From:
Sent: Sunday, August 3, 2025 9:21:04 AM
To: dc.admin@kirklees.gov.uk
<dc.admin@kirklees.gov.uk>
Subject: Planning Application 202591149

We are local residents living at Yew Tree House, Yew Tree Lane.

site plan as proposed  
Scale: 1:200

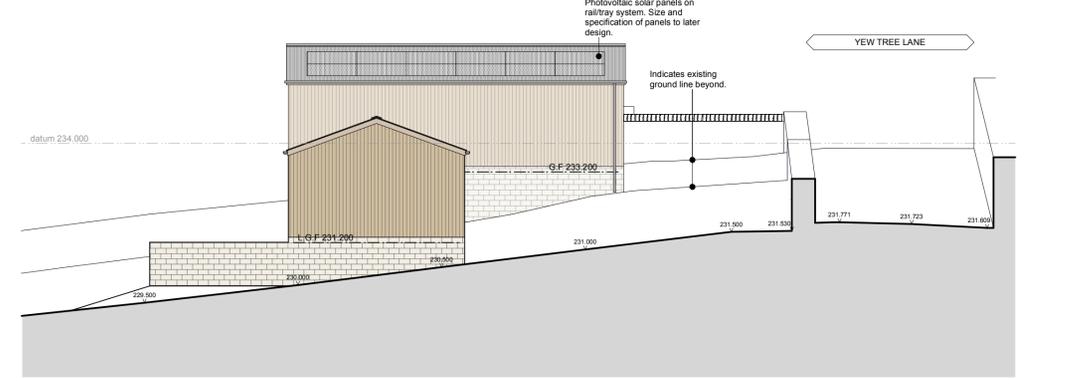
In the proposed plans there is the introduction of a stable block and an agricultural shed. This is a significant expansion of the current developed footprint of this site. These sheds will also block, obscure and change the views of the Holme valley from Yew Tree Lane, from the public footpath that runs through and the houses at the Yew Tree settlement. All of the new proposed footprint for stables and agricultural storage is currently in the building that is proposed to be repurposed as a domestic dwelling.

The development of the barn as a dwelling may be helpful in preserving the current agricultural building. The stables and sheds should be located to the rear of the proposed domestic development to protect the view for the public and residents of the Yew Tree settlement.

from and character of Yew Tree settlement. The chosen location could be located at the back of the proposed barn conversion as a compromise.
